CAMPBELL'S WAREHOUSE Remediation/Renewal The Rocks SSD 7056.

State Significant Development Application and Variation of the Sydney Cove Redevelopment Scheme for the “*Remediation, Renewal and Adaptive Re-Use of Campbell's Stores*”, The Rocks (SSD 7056)

Design Components Public Bays *Signage*

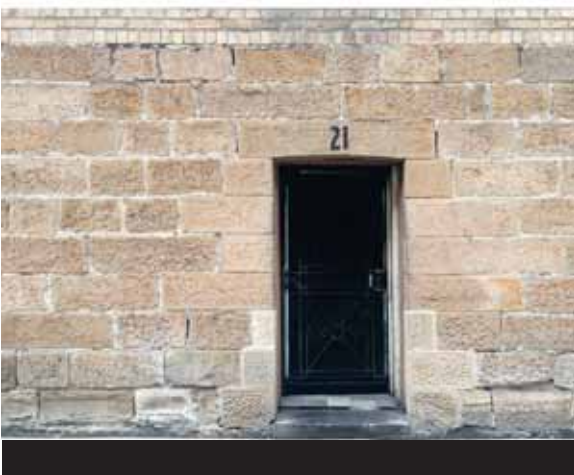
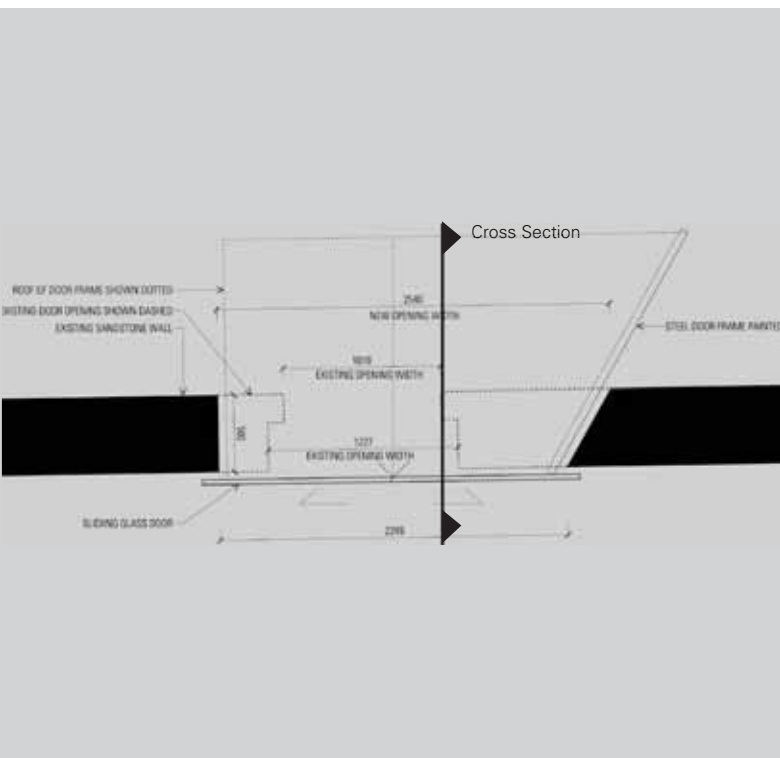
- The current proposal involves the introduction of new uses to the Hickson Road frontage. It involves unsympathetic alterations to existing openings including new concrete entry portals with back-lit signs and potentially the introduction of chairs and tables, umbrellas and street trees. The end result will be that the Hickson Road frontage will be cluttered, visually obscured and the ability understand the original form and use of this building of 'Exceptional' heritage significance will be reduced.

HICKSON ROAD ELEVATION (NTS)

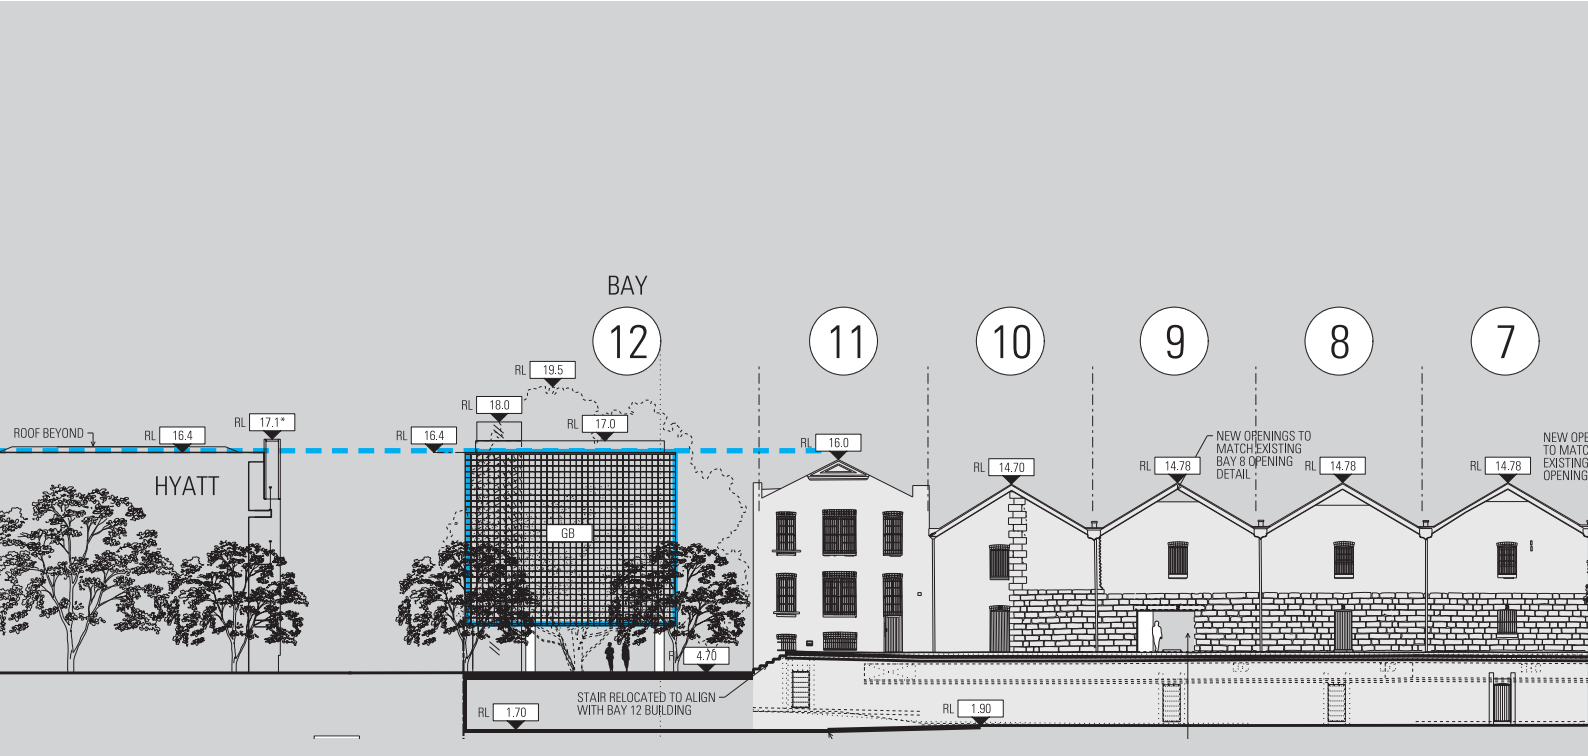
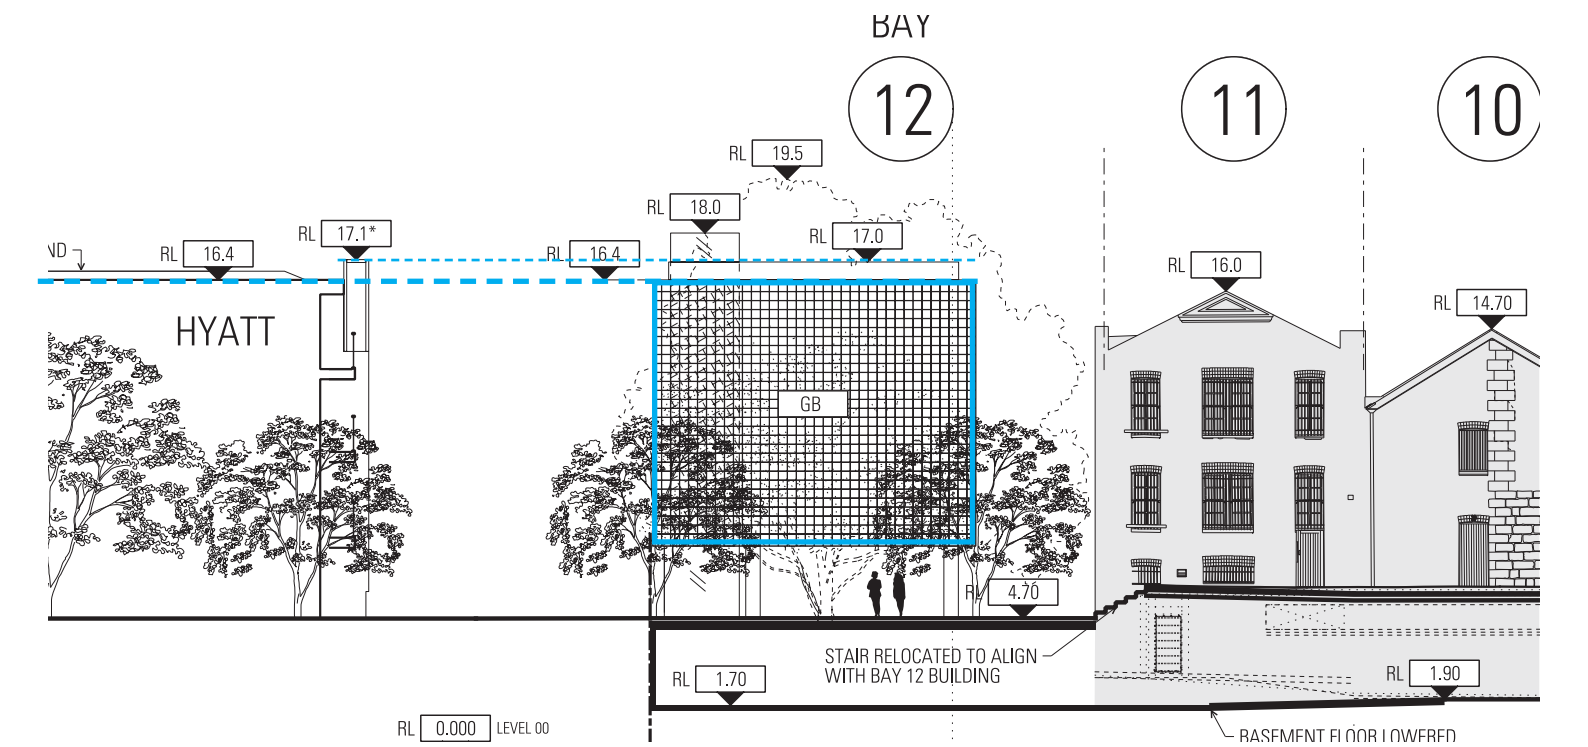
- The proposed new glass building does not comply with the current height limit and the applicant has applied for a "spot rezoning" to increase the height along the waterfront by more than five times the current permissible height limit - from RL3.5 to RL18.

- The proposal exceeds the height restriction on the foreshore **frontage by 14.5m, more than 250% and on the Hickson Road elevation by 10.5m, or 140%.**
